**From:** NATS Safeguarding <[NATSSafeguarding@nats.co.uk](mailto:NATSSafeguarding@nats.co.uk)>  
**Sent:** Thursday, October 31, 2024 2:17 PM  
**To:** Outer Dowsing Offshore Wind <[OuterDowsingOffshoreWind@planninginspectorate.gov.uk](mailto:OuterDowsingOffshoreWind@planninginspectorate.gov.uk)>;  
Outer Dowsing Offshore Wind <[contact@outerdowsing.com](mailto:contact@outerdowsing.com)>  
**Cc:** Chris Jenner [REDACTED]; NATS Safeguarding  
<[NATSSafeguarding@nats.co.uk](mailto:NATSSafeguarding@nats.co.uk)>; Greg Tomlinson [REDACTED] ROSSI,  
Sacha [REDACTED]  
**Subject:** EN010130 ODOW DCO Application - Change Consultation [SG33815]

For Outer Dowsing Offshore  
Wind Farm Development

NATS ref: SG33815

The Planning Inspectorate submitted a request for a NATS technical and operational assessment (TOPA) for the development at Outer Dowsing Offshore Wind Farm. It will comprise a large number of turbines up to 403m in height within the boundary points as detailed in Table 1 and contained within an area as shown in the diagrams contained in Appendix B.

Figure 16.1

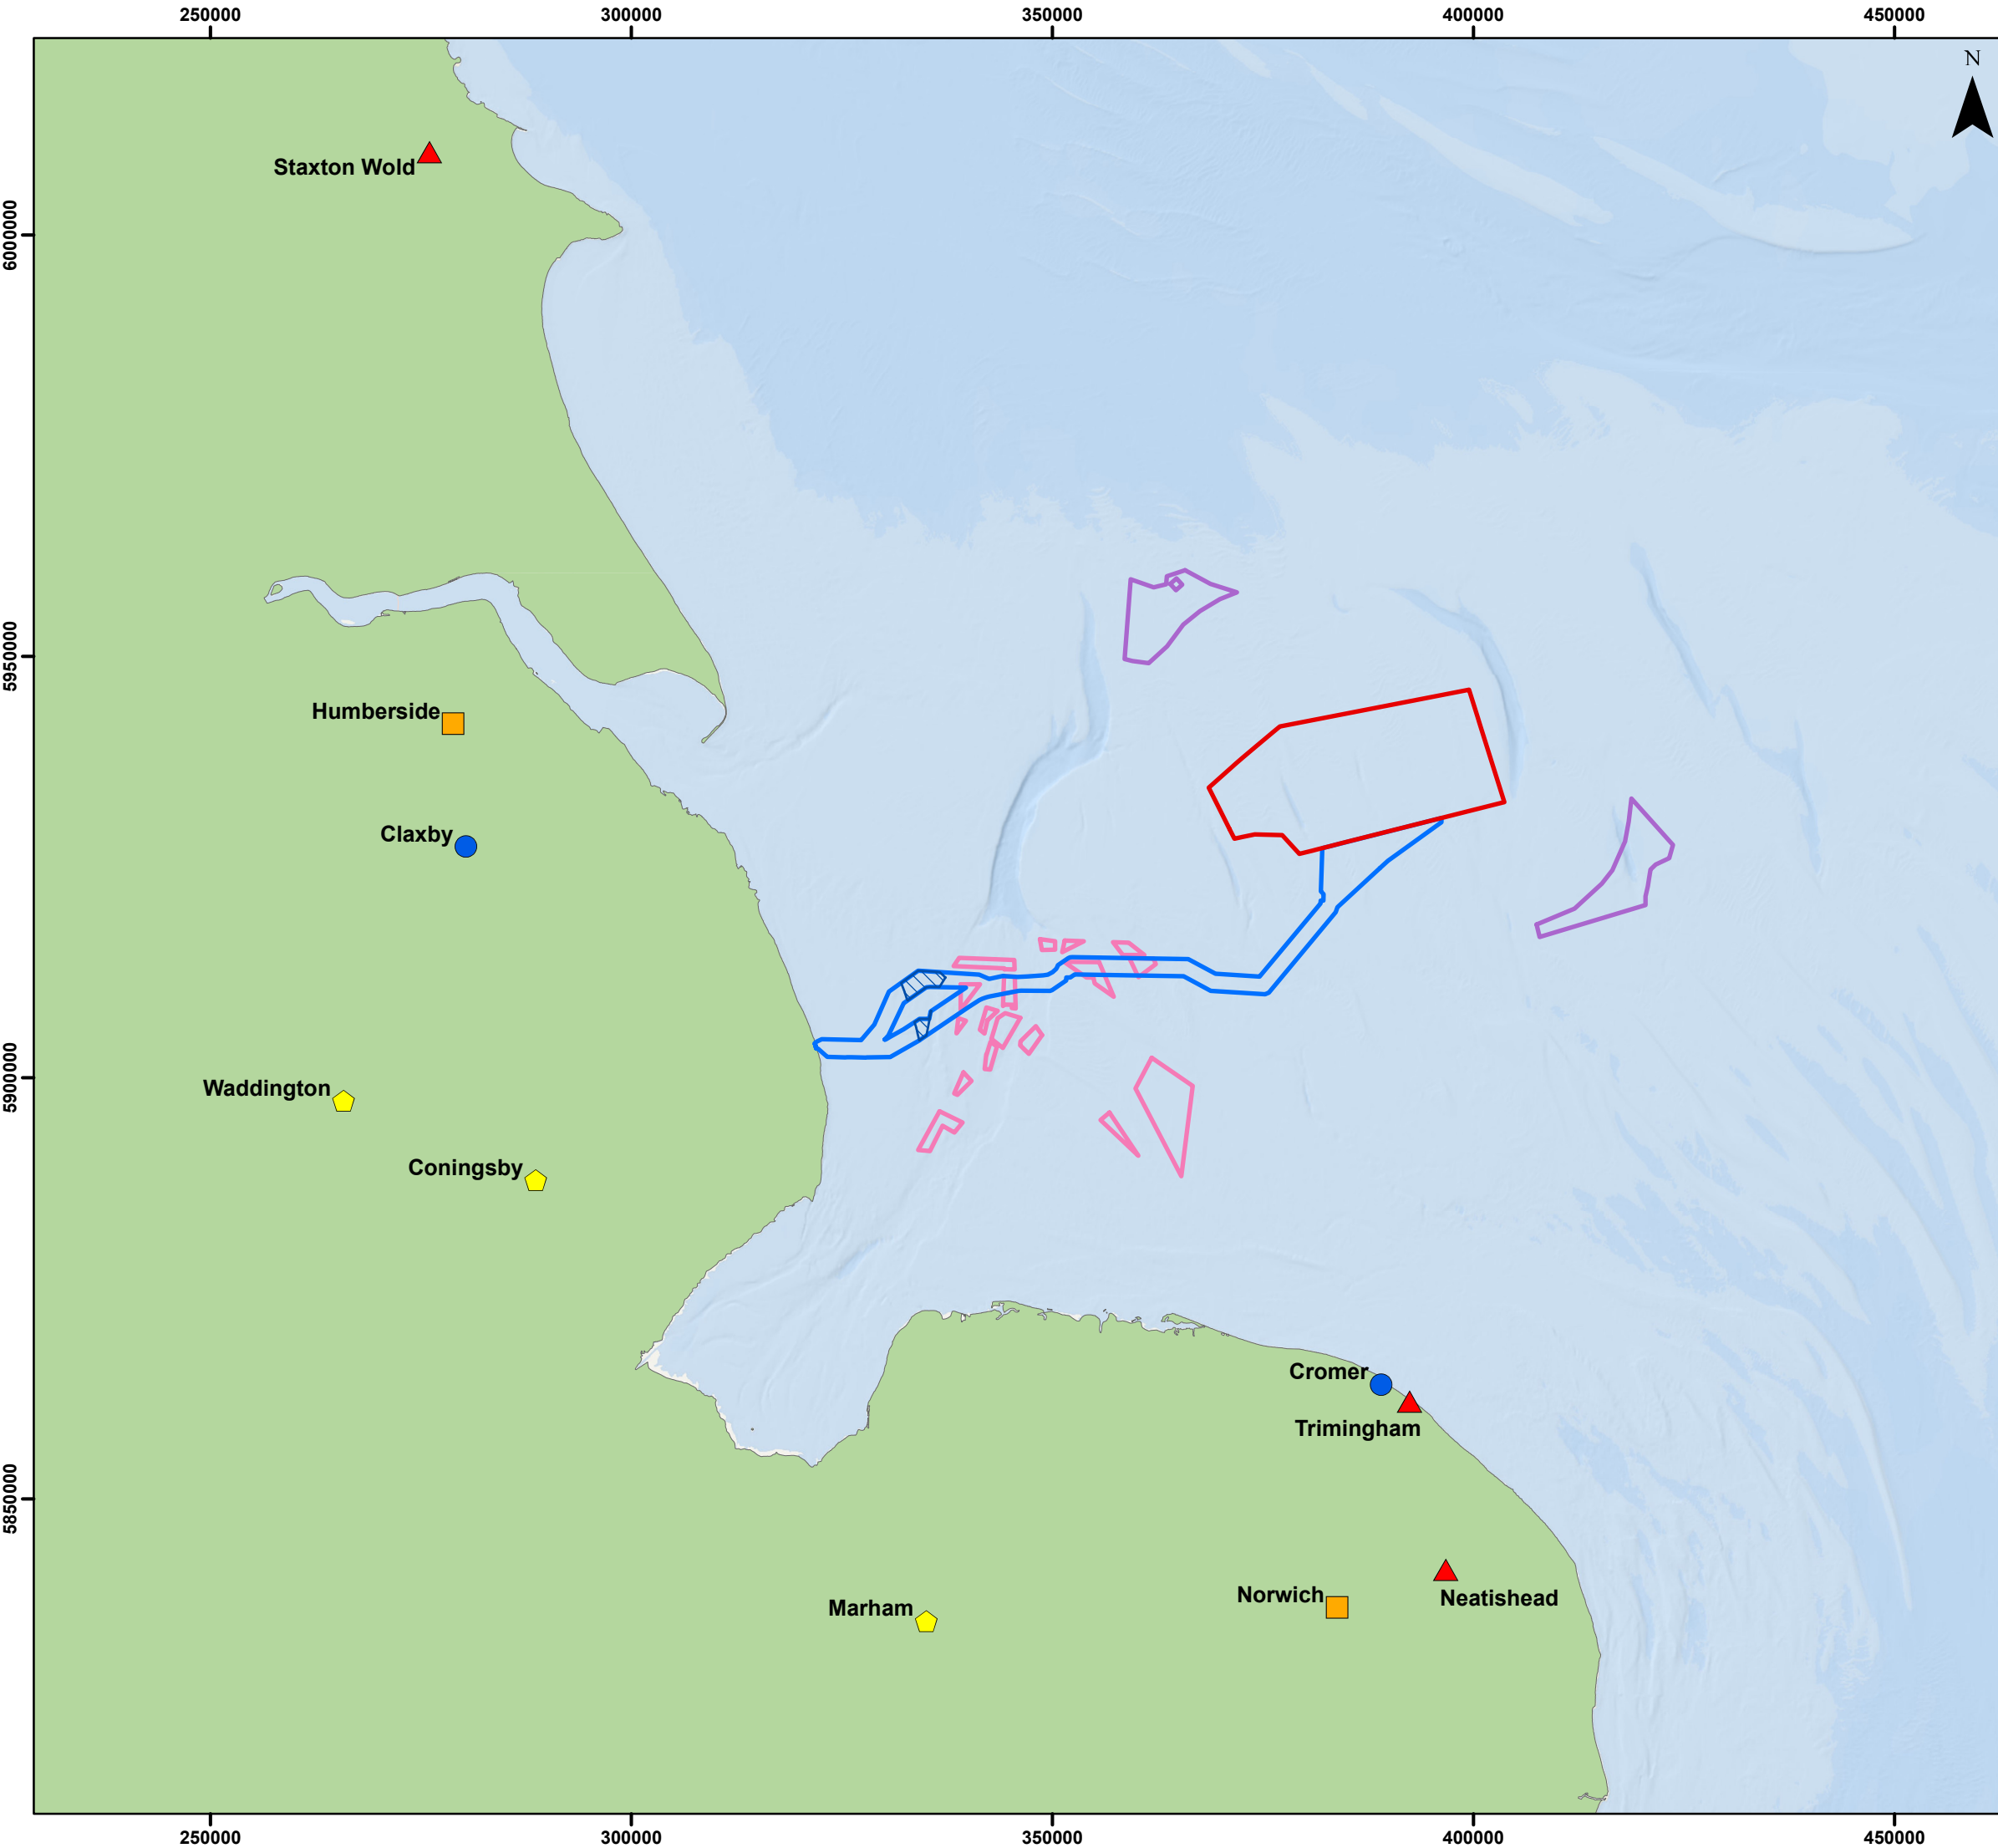
Using the theory as described in Appendix A and development specific propagation profile it has been determined that the terrain screening available will not adequately attenuate the signal, and therefore this development is likely to cause false primary plots to be generated. A reduction in the RADAR's probability of detection, for real aircraft, is also anticipated.

Using the theory as described in Appendix A and development specific propagation profile it has been determined that the terrain screening available will not adequately attenuate the signal, and therefore this development is likely to cause false primary plots to be generated. A reduction in the RADAR's probability of detection, for real aircraft, is also anticipated.

The proposed development has been examined by technical and operational safeguarding teams. A technical impact is anticipated, this has been deemed to be unacceptable.
